## El Paso County Park Advisory Board

### Agenda Item Summary Form

**Agenda Item Title:** Esteban Rodriguez Preliminary Plan

**Agenda Date:** December 11, 2024

SHEET TITLE: PRELIMINARY PLAN

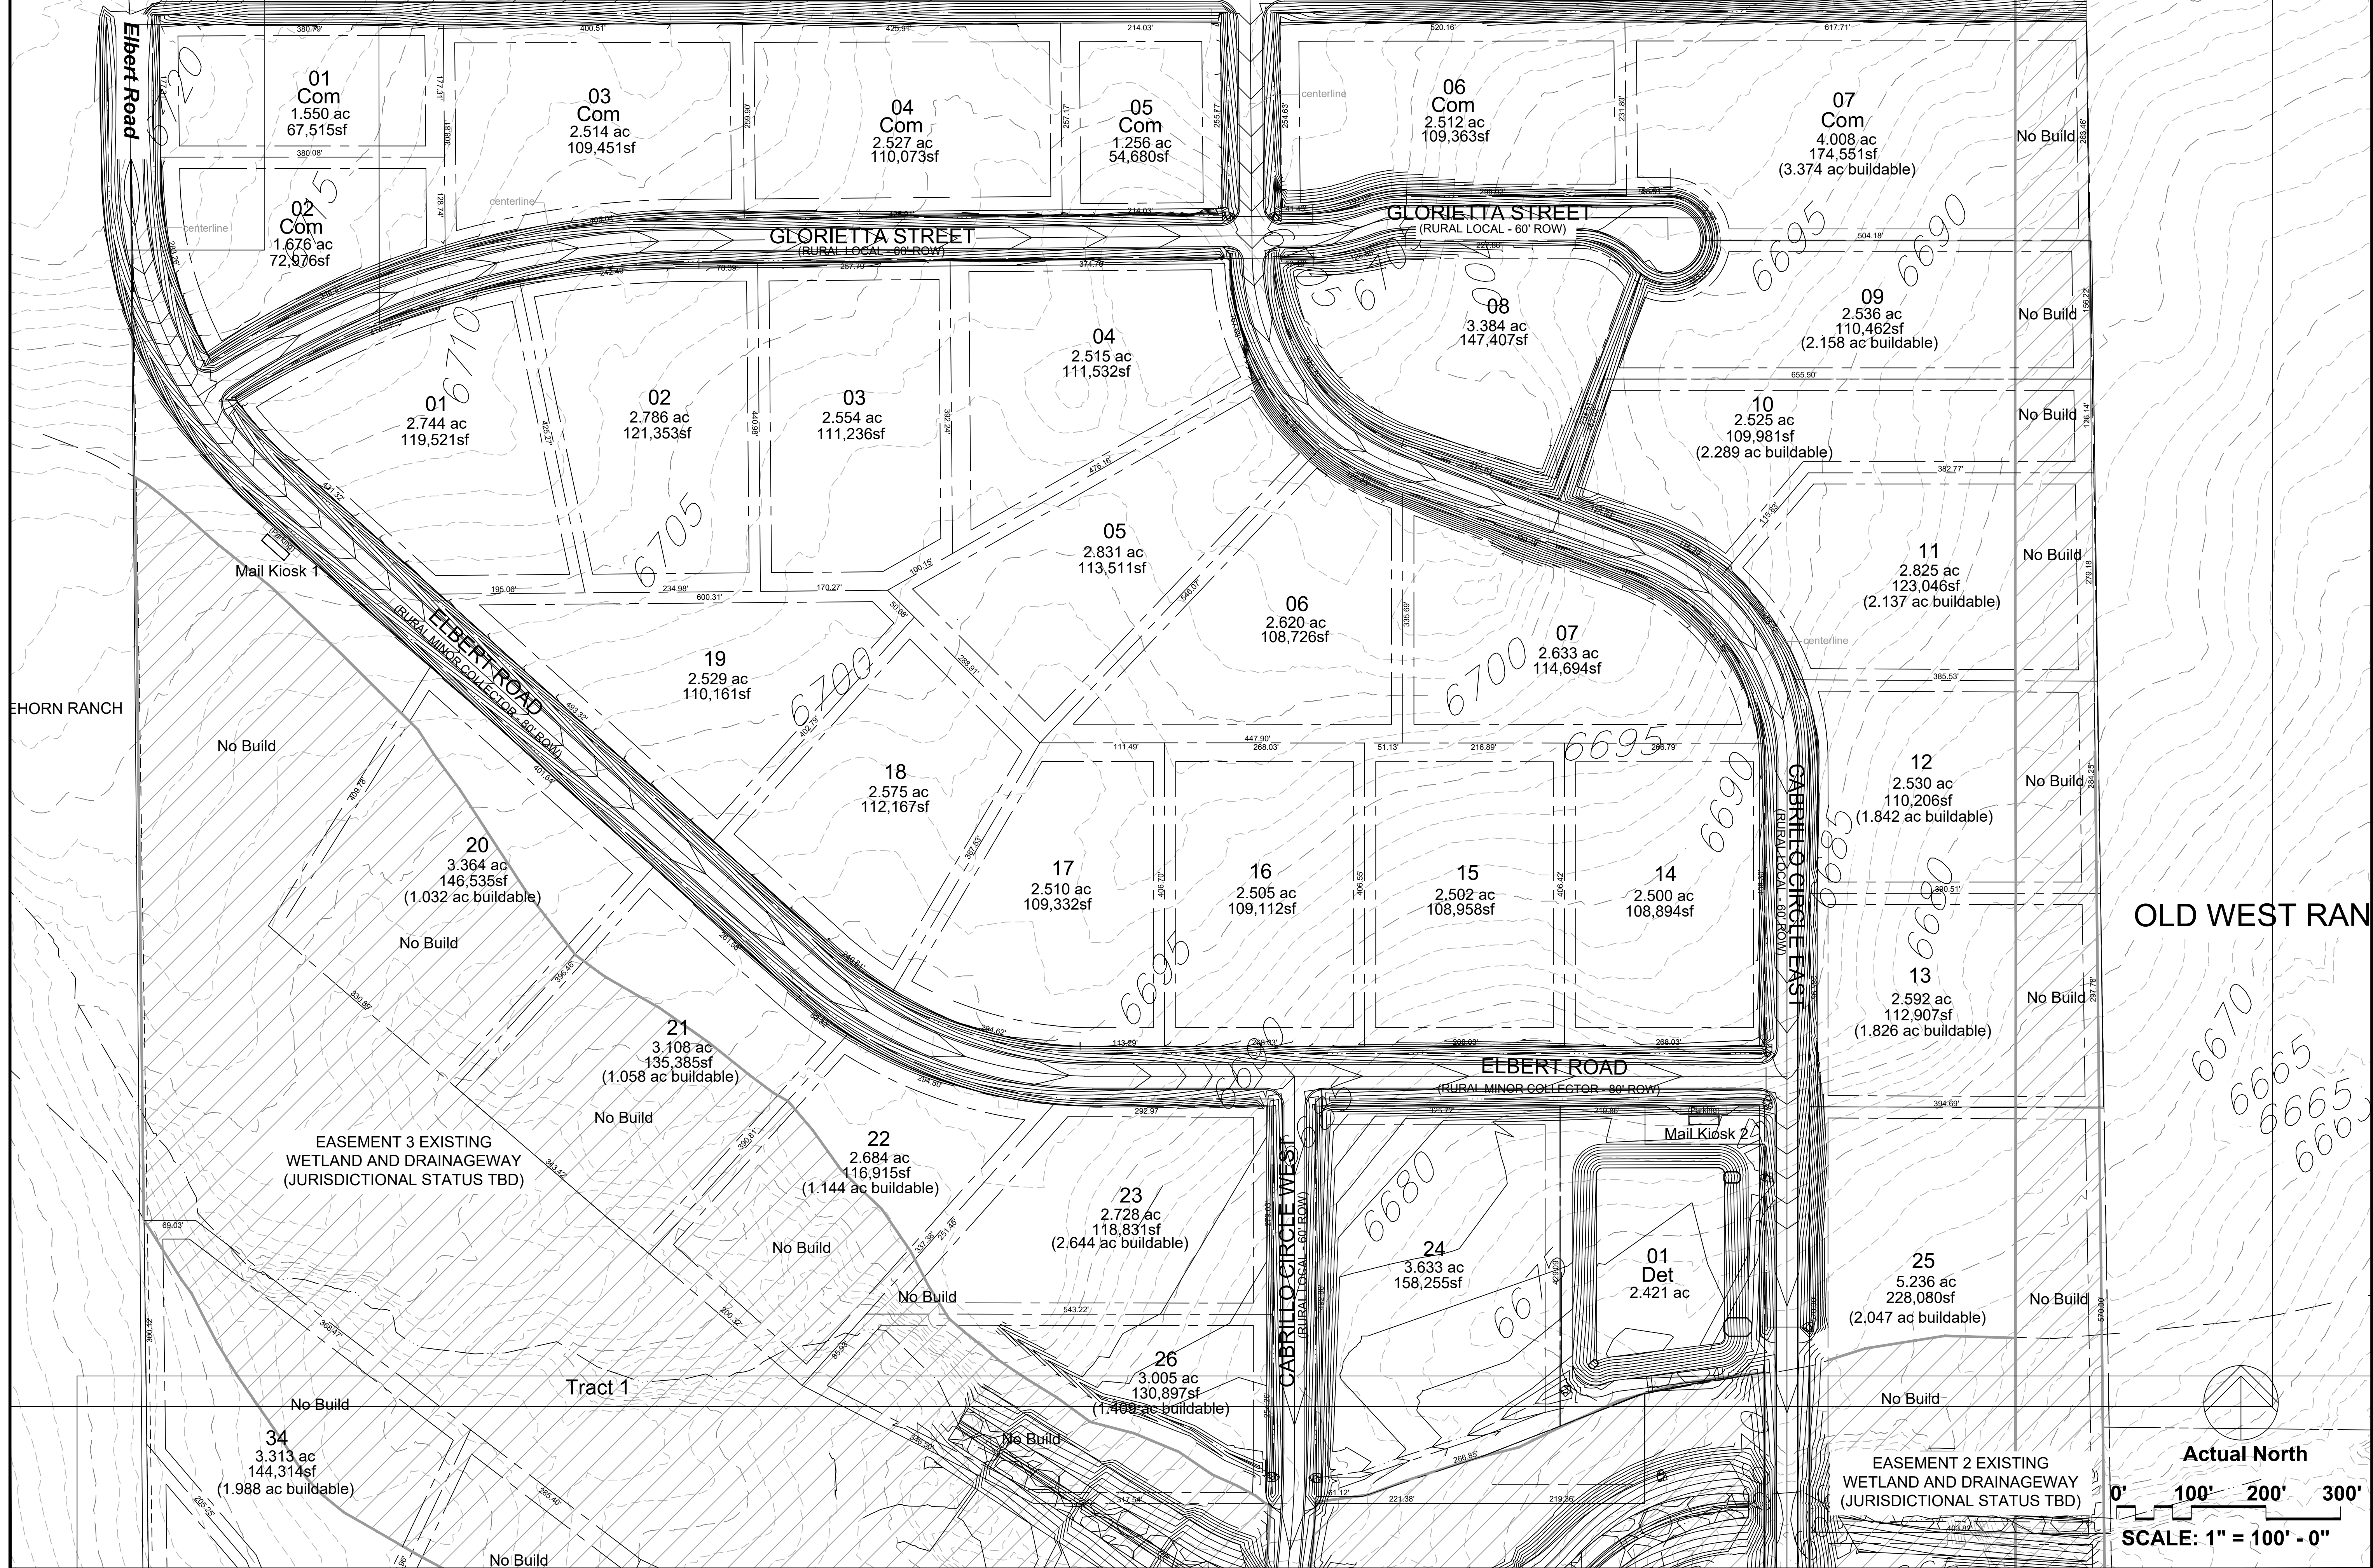
Due to nonconformity of the Preliminary Plan in relation to the approved Sketch Plan, staff asks that the applicant address the removal of the previously approved 8.44-acre community park, add the park to future submittals of the Preliminary Plan, clearly display and notate the internal trail corridors and public trail easements as were originally shown and noted on the Sketch Plan, and resubmit the Preliminary Plan for further review.

The Park Advisory Board recommends that the Planning Commission and the Board of County Commissioners include the following condition when considering and/or approving the Esteban Rodriguez Preliminary Plan: (1) address the removal of the 8.44-acre community park, and add the park to forthcoming submittals of the Preliminary Plan; (2) display and notate the internal trail corridors and public trail easements; (3) fees in lieu of land dedication for regional park purposes in the approximate amount of \$72,720 will be recalculated prior to and required at time of the recording of the forthcoming Final Plat(s).
